Application No: BR/112/20/PL
Site Address: 14a Canada Grove Bognor Regis PO21 1DN
Description of works: Single storey rear extension

Thank you for your internet representation made on 18th June 2020 which has been recorded as an objection with the comments as follows:

PROPOSED SINGLE STOREY EXTENSION AT 14a, CANADA GROVE, BOGNOR REGIS
FOR MRS. D. KEIRNAN.

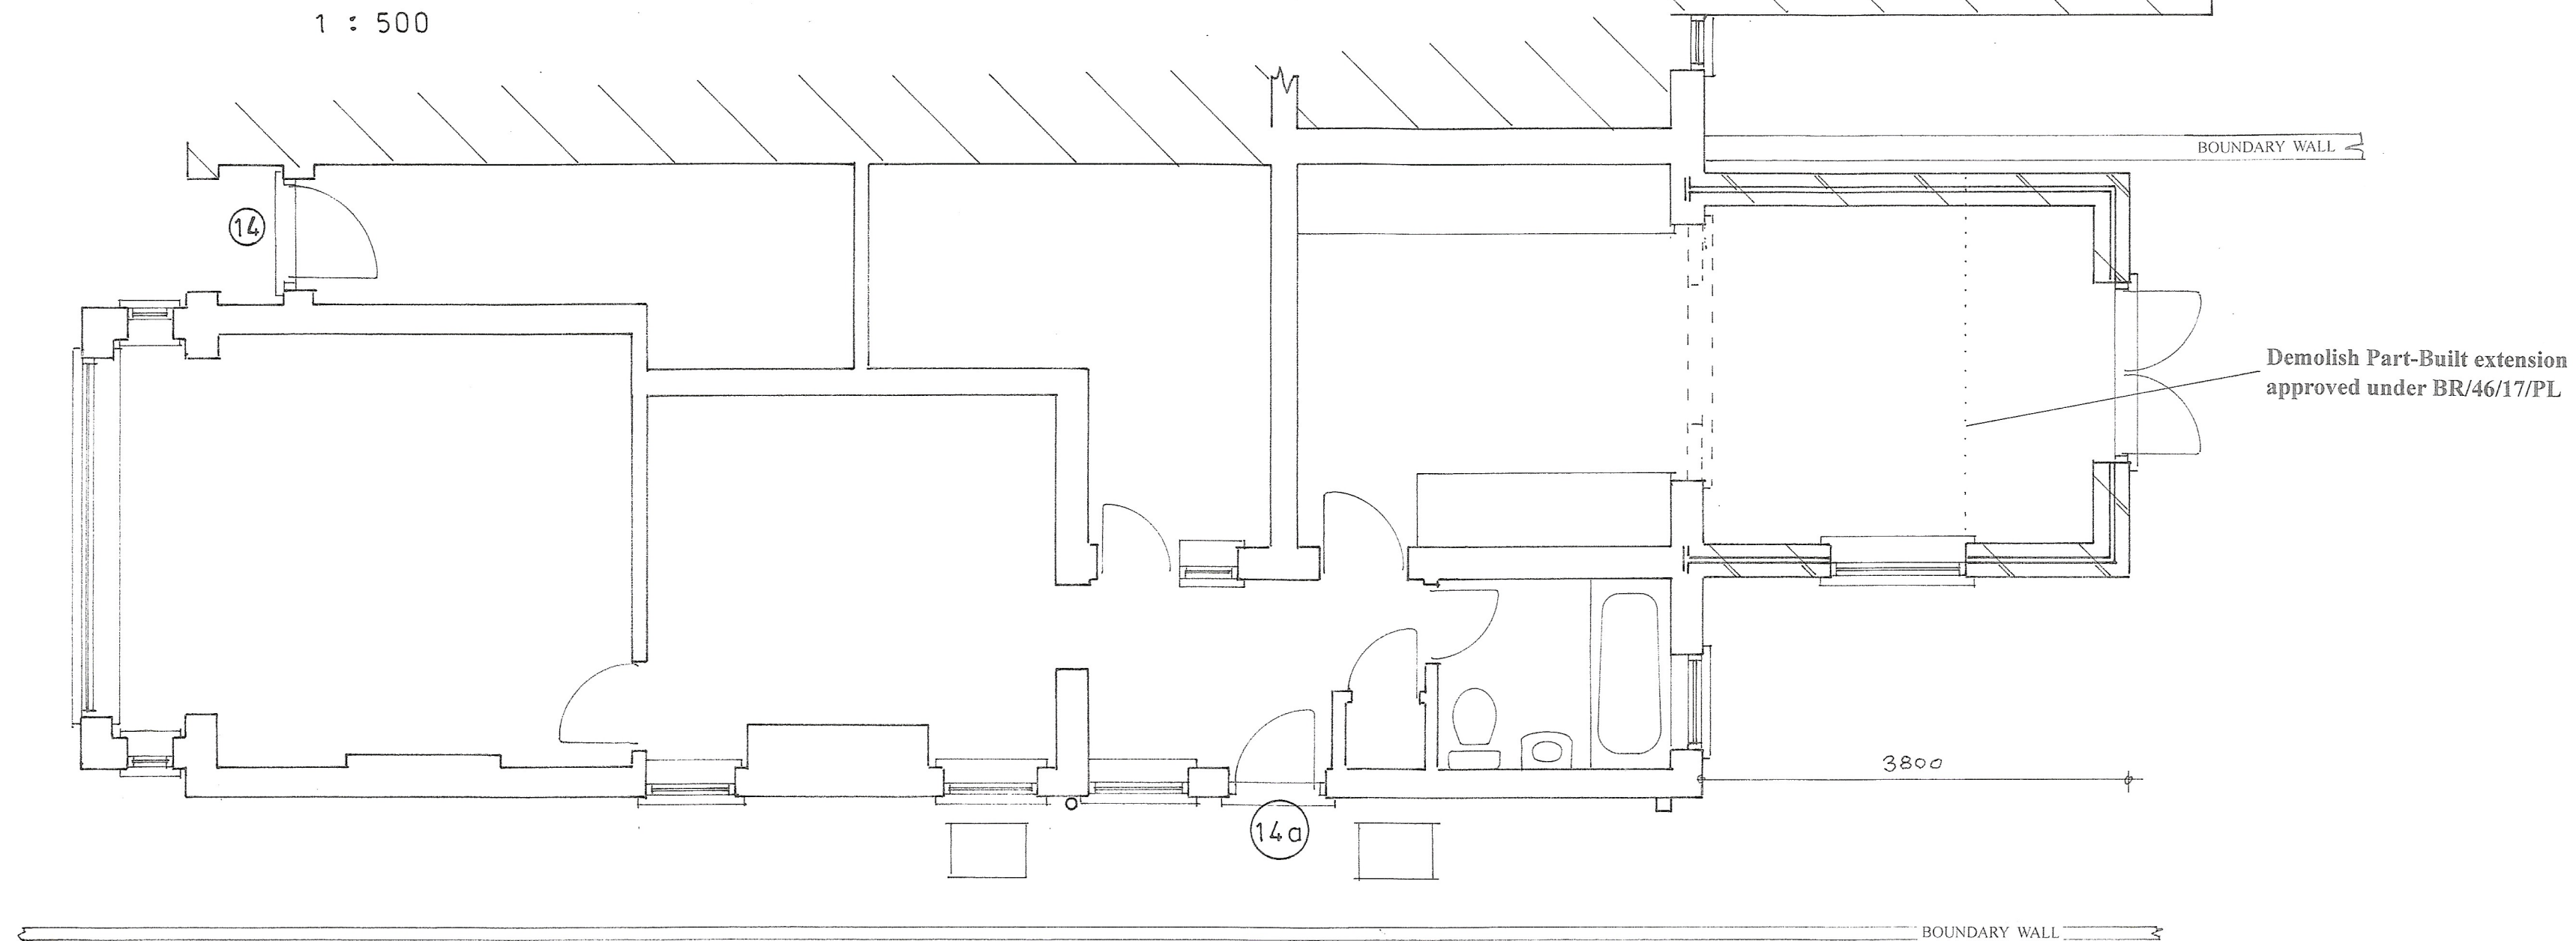
I live in the neighbouring property and previously objected to the planning application made under ref BR/46/17/PL on the basis that I was concerned that once the works were completed the 2.3m projection with high eaves on the proposed pitched roof, the light entering my property would be severely restricted. The works were never completed and now has been demolished. To be replaced with a 3.8m projection extension- again adjacent to our boundary.

The extension to the rear of the property was built away from the boundary line which meant that the extension was not over bearing on 14A Canada Grove. The conversion of my property also left a window on the original back wall which is now the only window serving my bedroom. If a 3.8m extension is built at number 14A, adjacent to the boundary line, that building will be overbearing on my property and will significantly impeded upon the light entering my bedroom.
